Narromine to Narrabri (N2N) Inland Rail Response to Exhibition of Preferred Infrastructure and Amendment Report – Narrabri Shire Council Submission

PREFERRED EXHIBITION & AMENDMENT REPORT FOR INLAND RAIL – NARROMINE TO NARRABRI (N2N)

SSI-9487

NARRABRI SHIRE COUNCIL SUBMISSION REPORT

Figure C3.4 Indicative layout - borrow pit D (Perimeter Road, Narrabri)

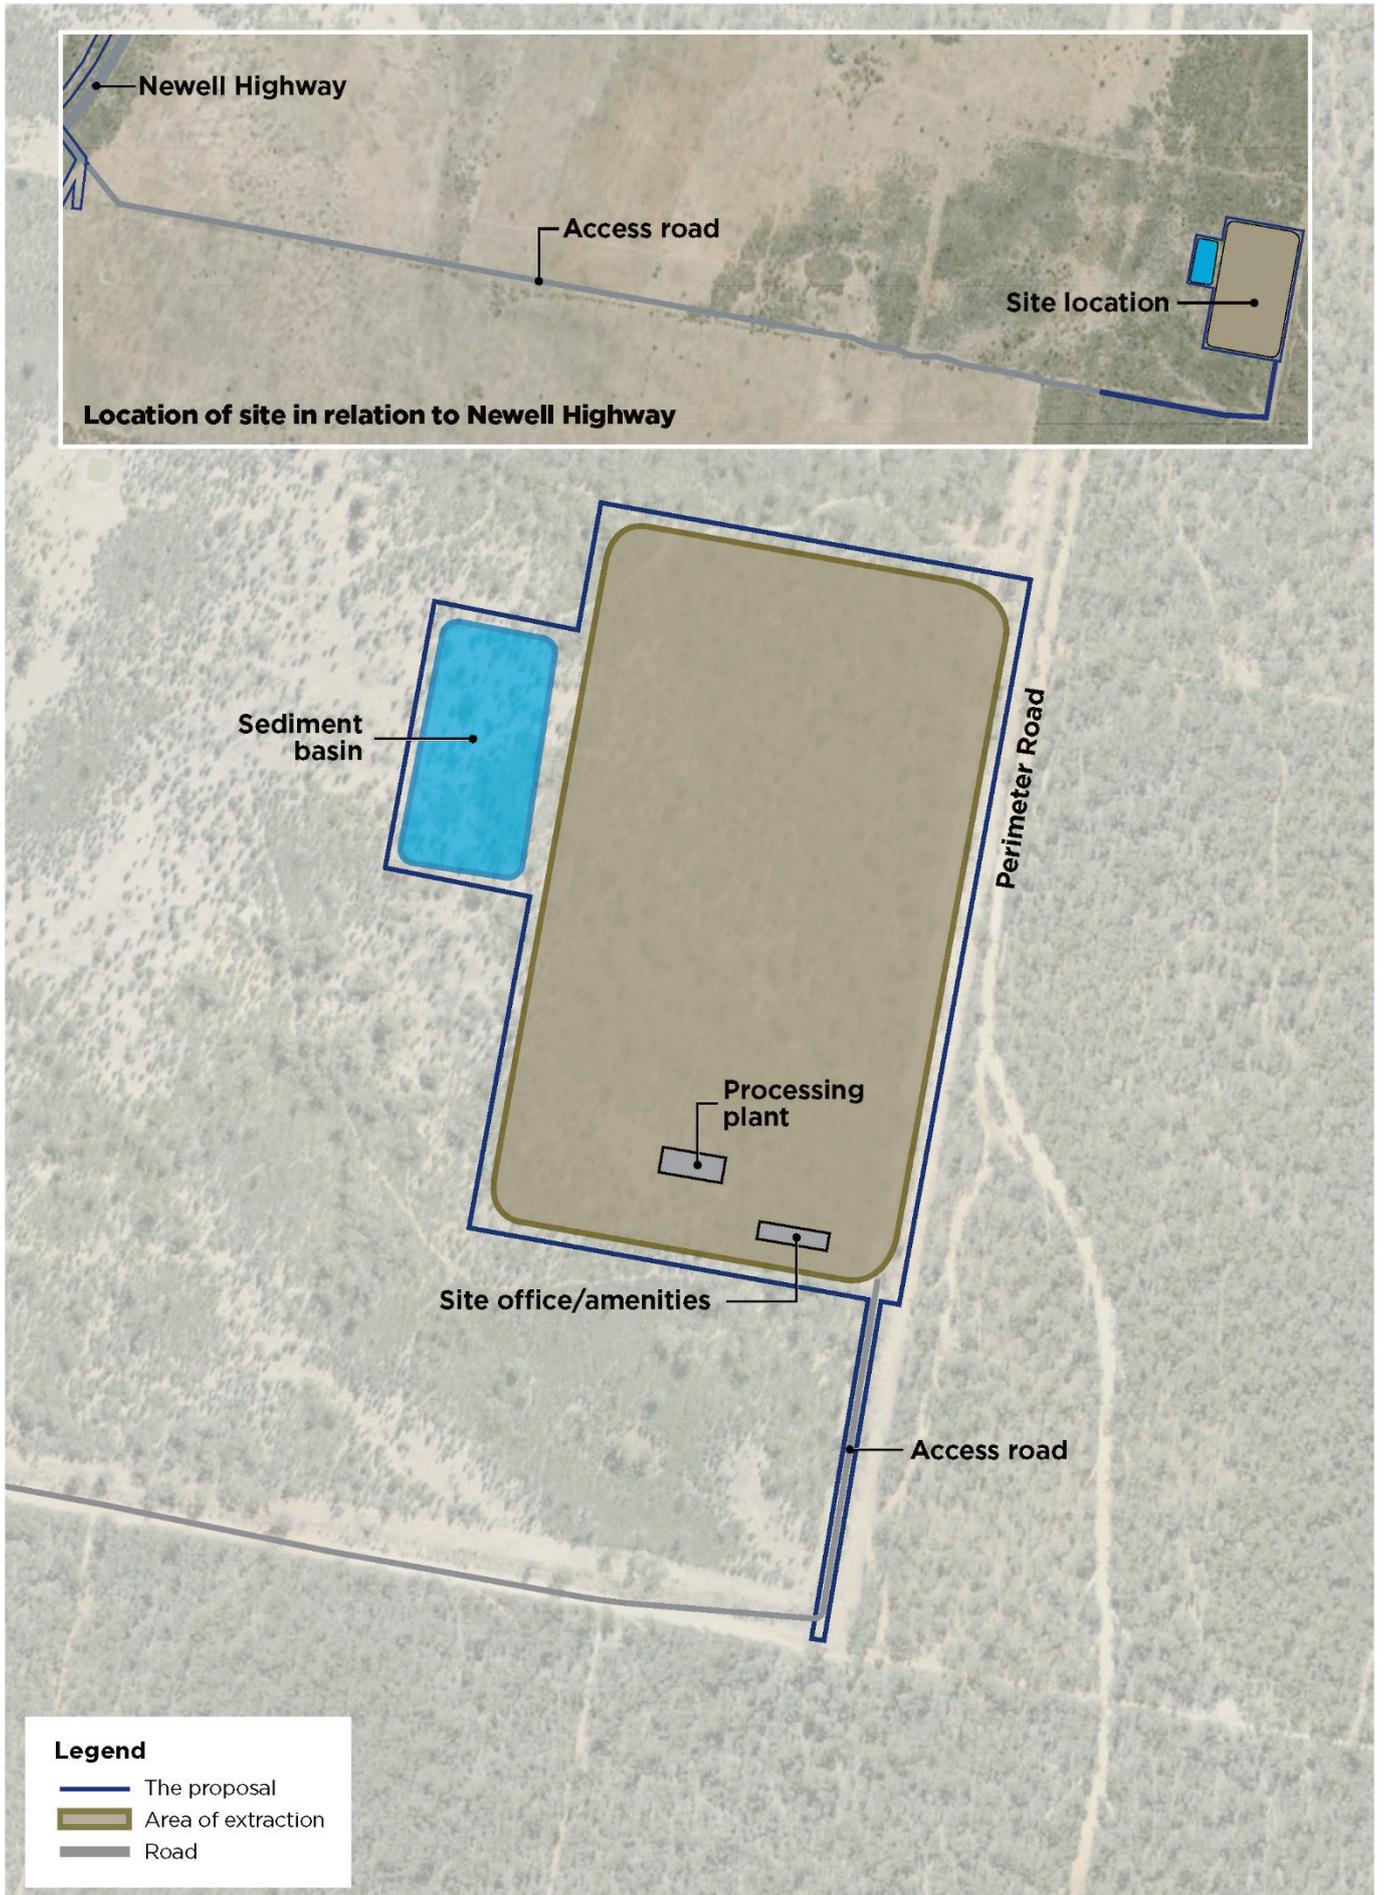
10. The compressed nature of the public exhibition period which has created organisational stress during a period of unprecedented development activity. A review of over 4000 pages of information has been required in only twenty one (21) days.
11. The response to Council's previously communicated concerns in relation to Stakeholder Engagement within the Response to Submissions Report (section 4.3.2) is noted.
12. It is acknowledged that approval for the proposed Borrow Pit D, located at Jacks Creek, is being sought and approval/concurrence from Narrabri Shire Council is not required.

- Local heritage management; and
 - The proposed traffic, road network and general environmental impacts in respect of proposed Borrow Pit D, located at Jacks Creek be fully considered and managed, including an opportunity to review and provide feedback on any Quarry Management Plans (or their equivalent).
